BM:LD:AA | SSD-29508870

9 November 2022

**SUBJECT: BIRRIWA SOLAR FARM (SSD-29508870)**

Thank you for providing Mid-Western Regional Council (Council) with the opportunity to provide comment on the Environmental Impact Statement (EIS) Birriwa Solar Farm (SSD-29508870). Council has reviewed the document and provides the following comments.

BARNEYS REEF ROAD UPGRADE

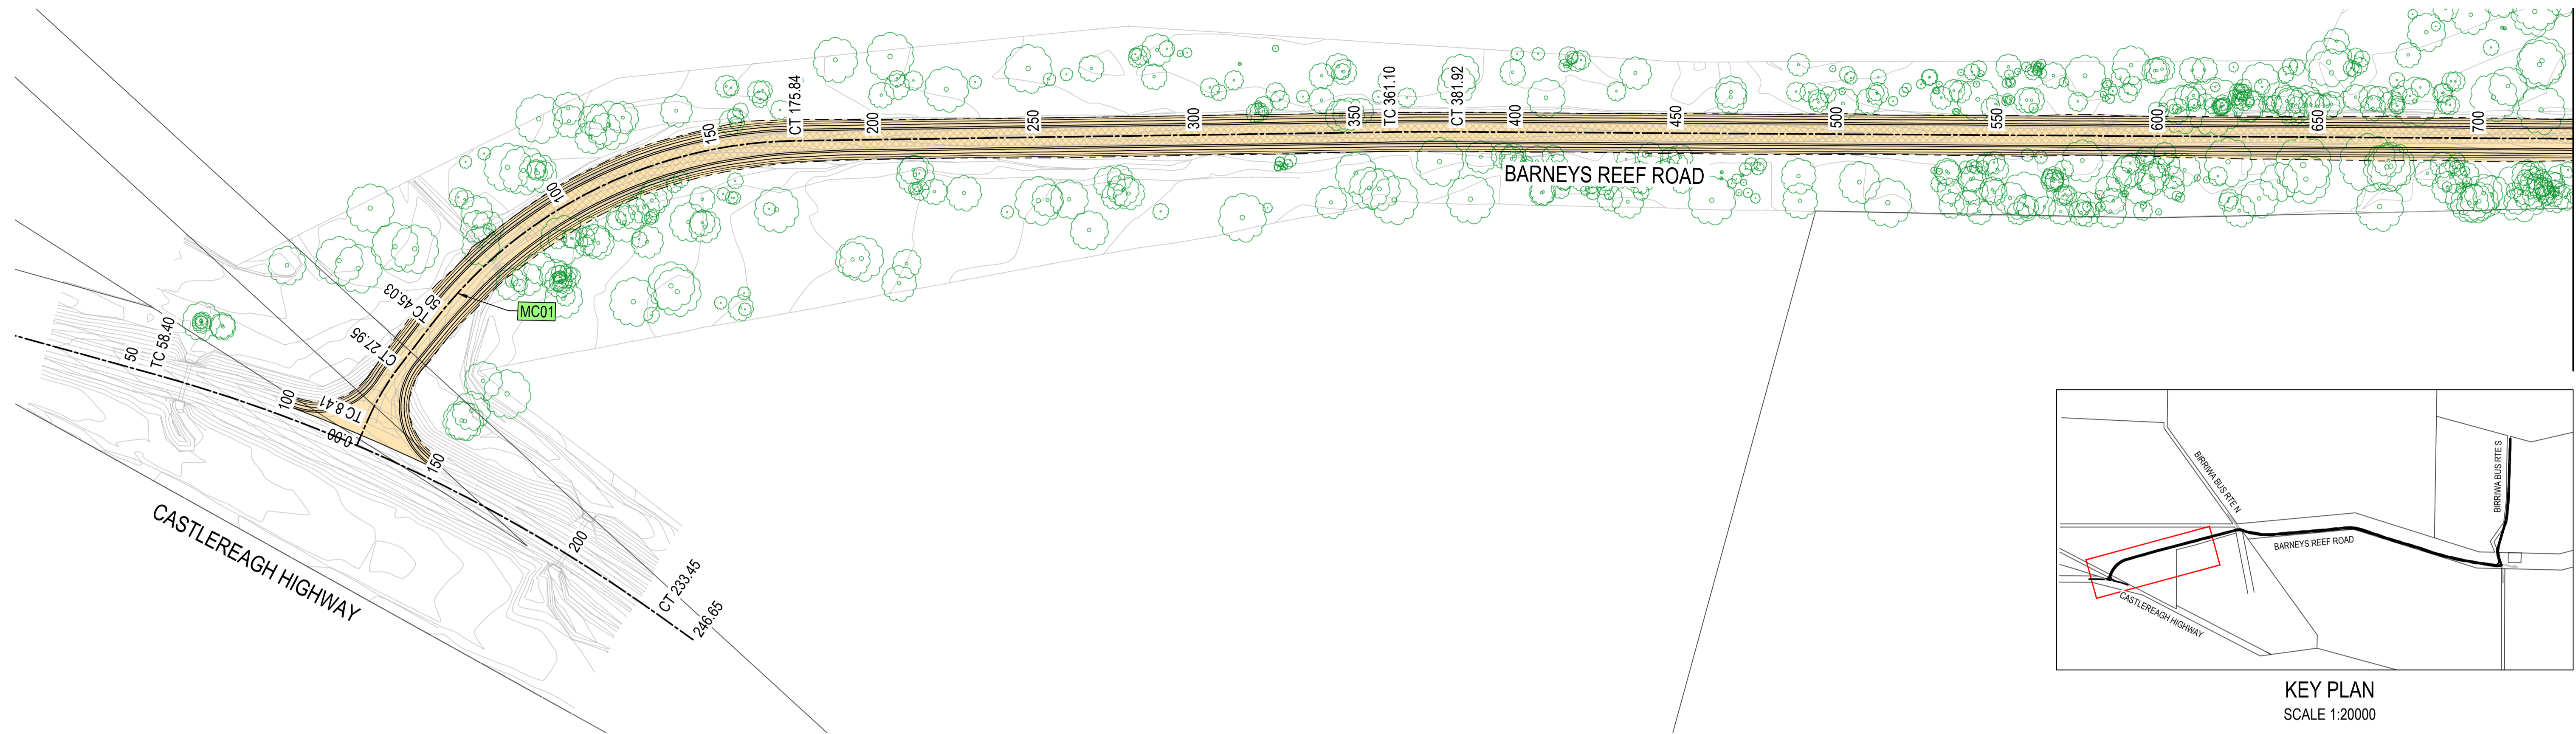
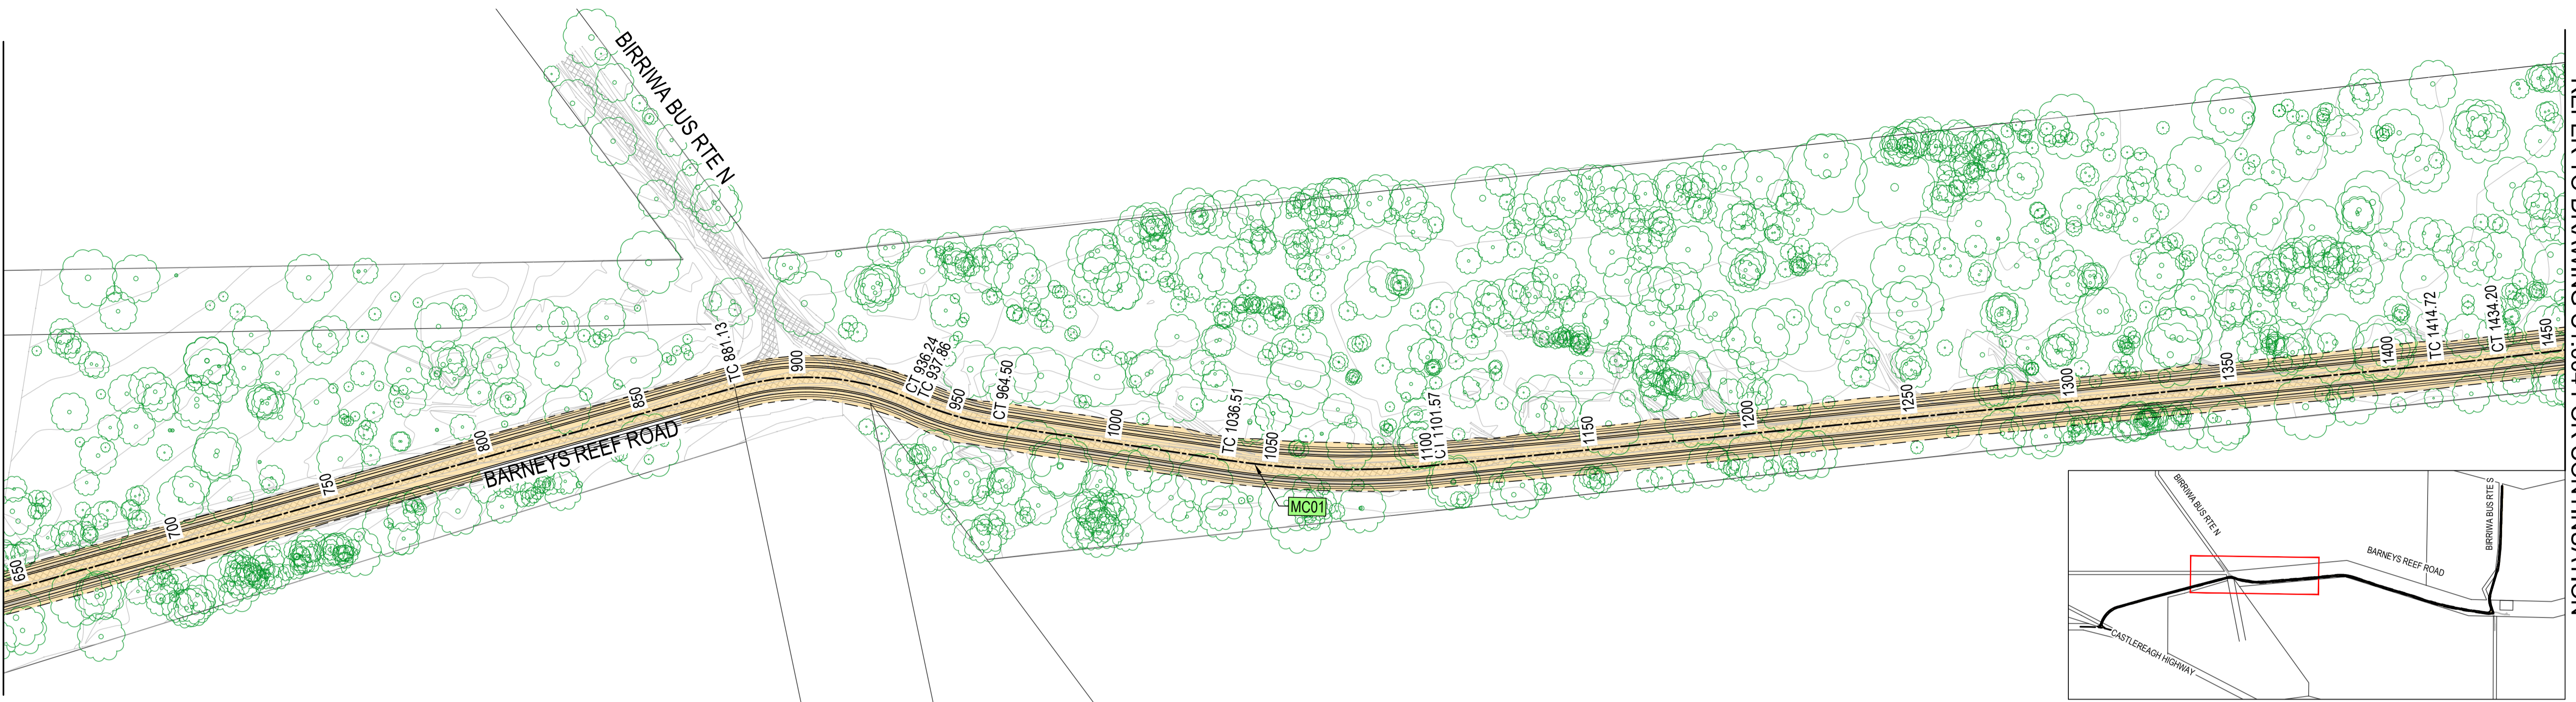
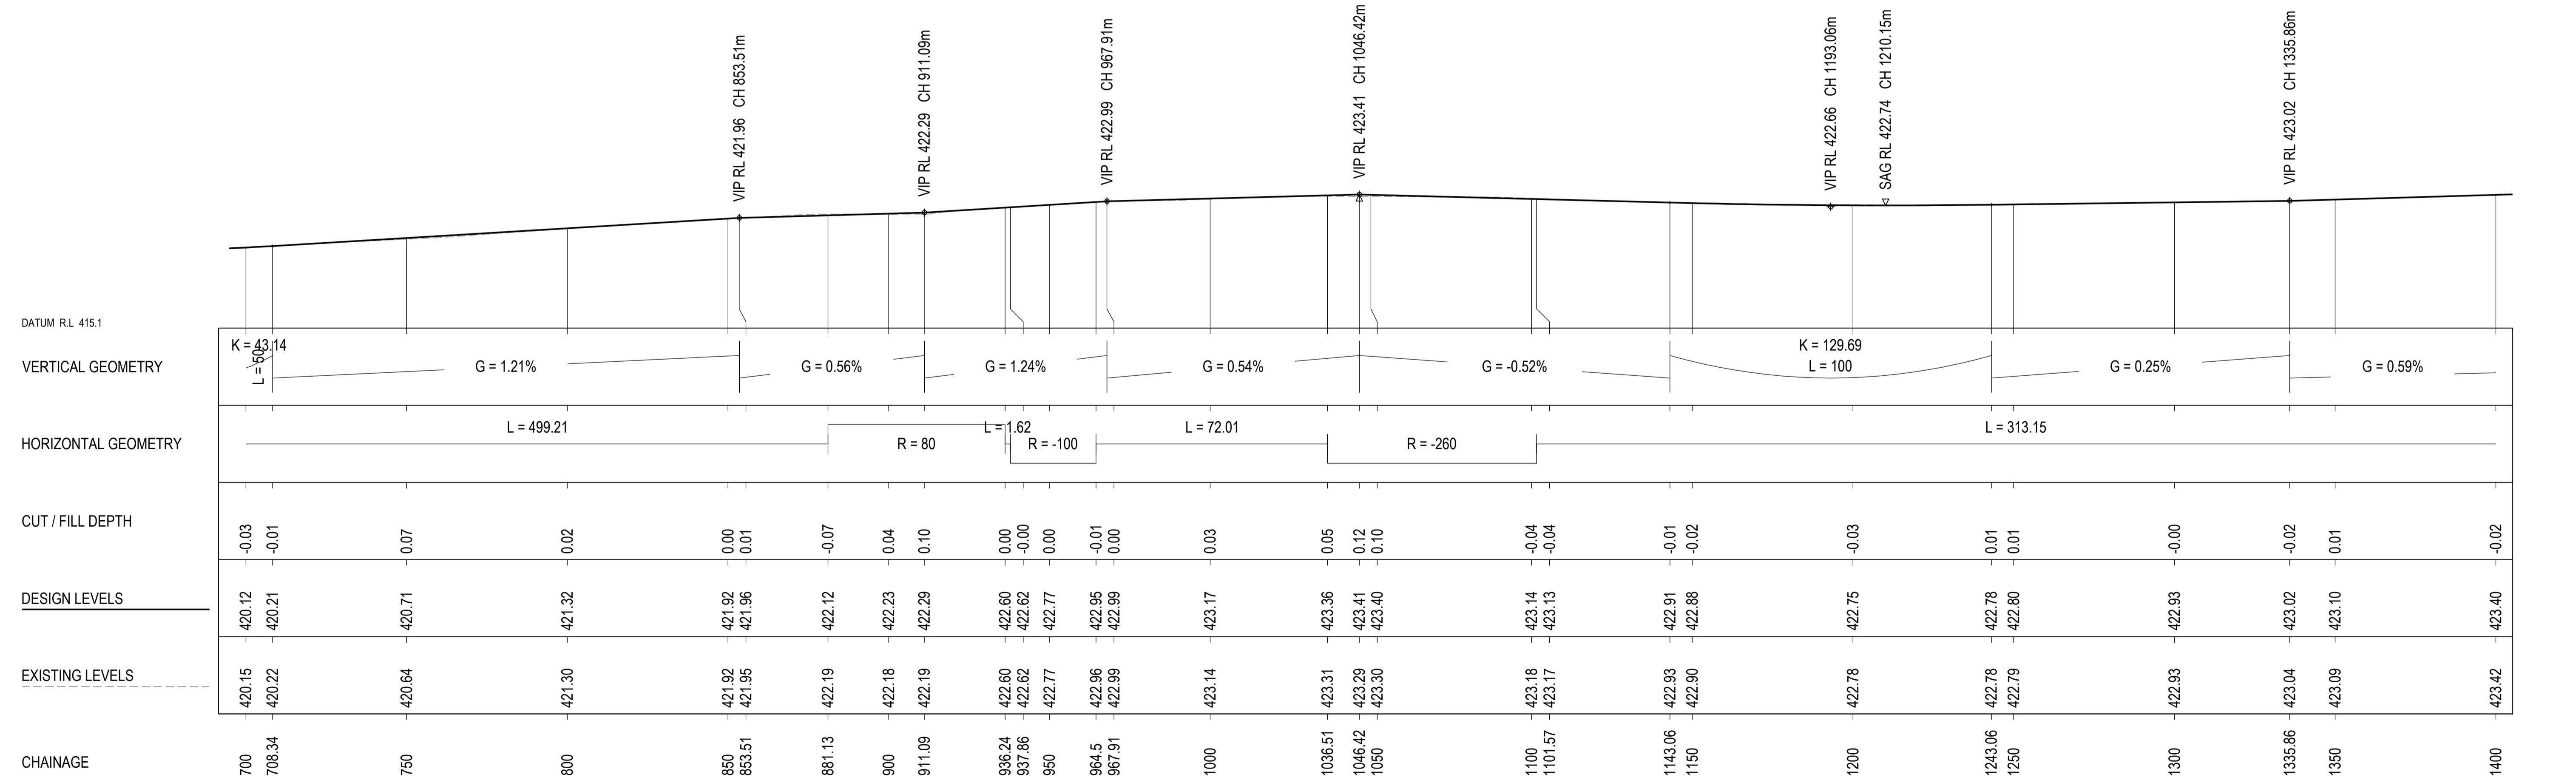
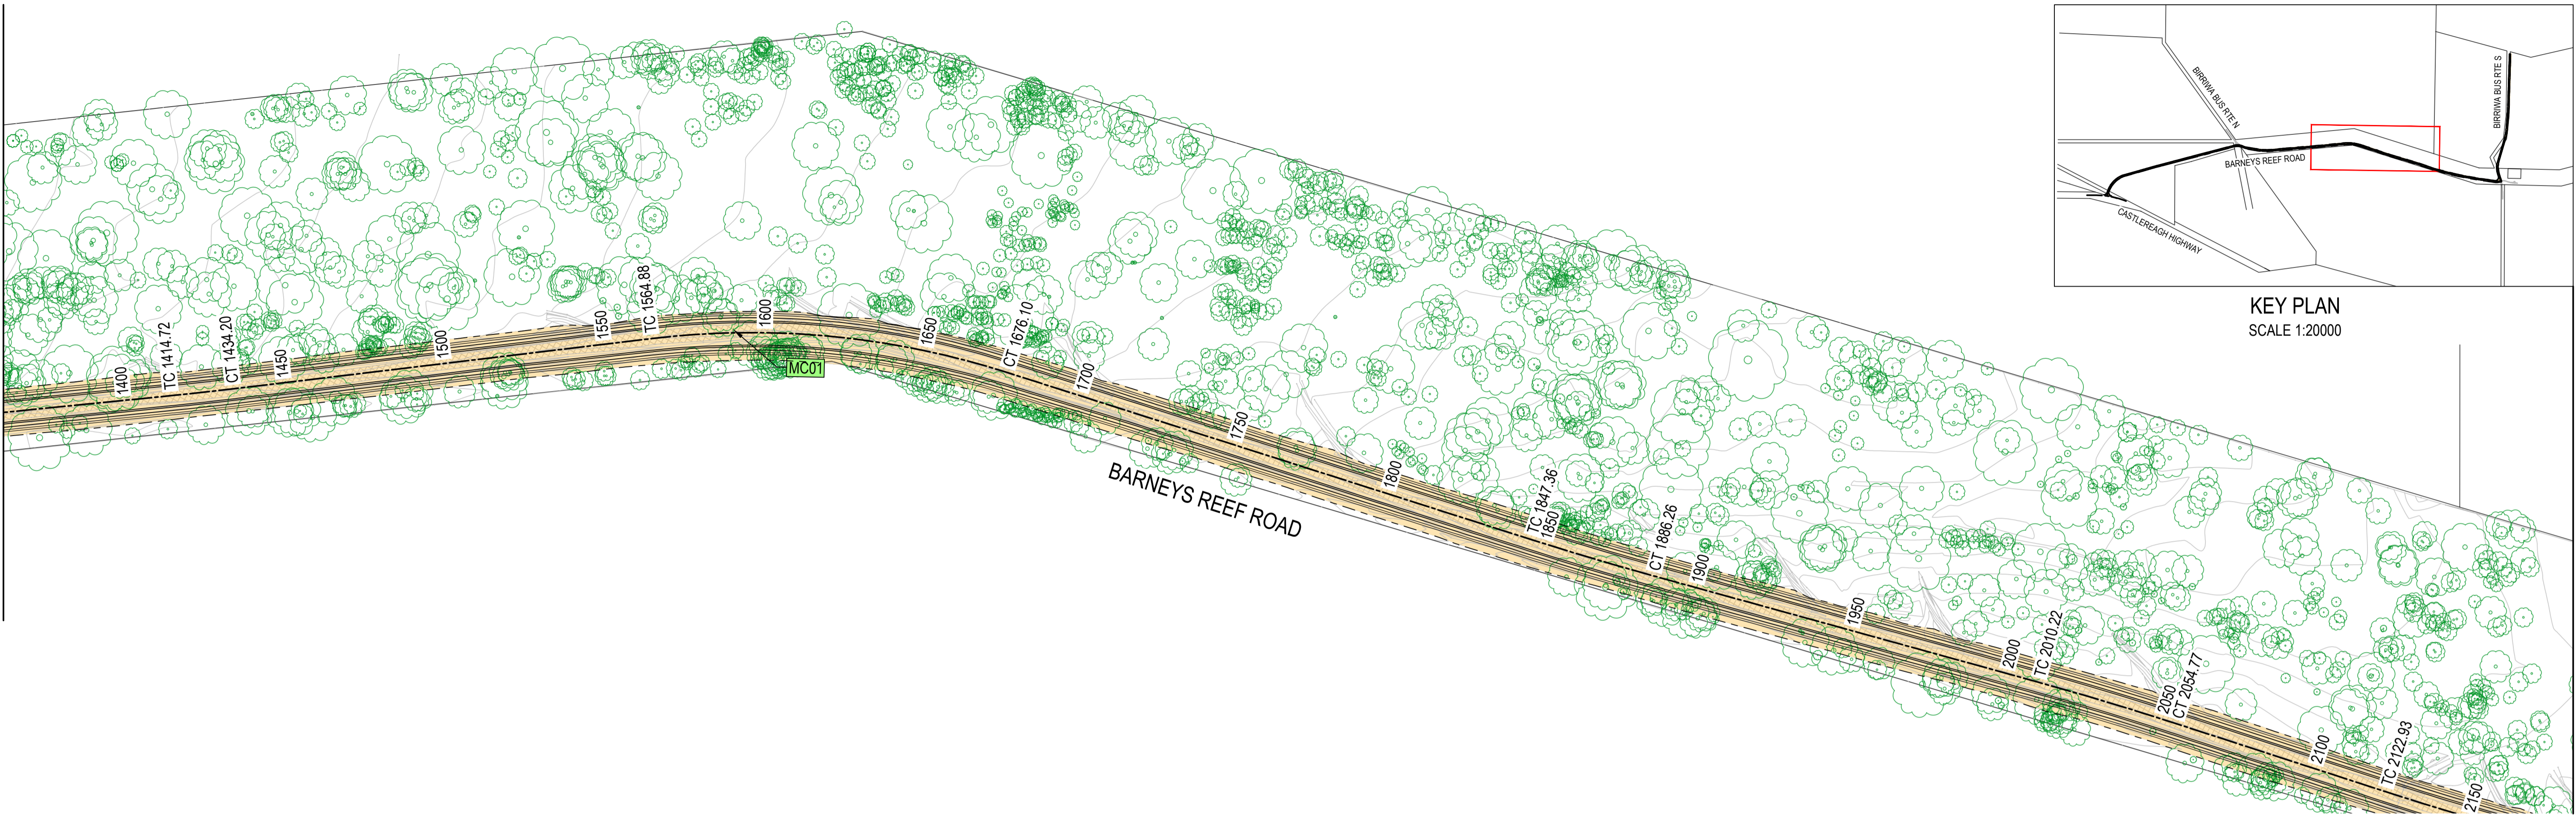
Barneys Reef is deemed to be a suitable access road subject to the following;

- Road widening is conducted where required with minimal impact on trees
- Small piped culverts are installed where required
- The mitre drains are deepened
- The road pavement receives additional gravelling for the traffic loadings and sealing
- The pavement thickness is determined by a geotechnical assessment
- The intersection of Barney Reef Road and Castlereagh Highway is referred to Transport NSW for consideration and conditioning

Further, the pavement on the Birriwa Bus Route is to be of the same standard as Barneys Reef Road and the existing concrete culvert is to be assessed for structural adequacy.
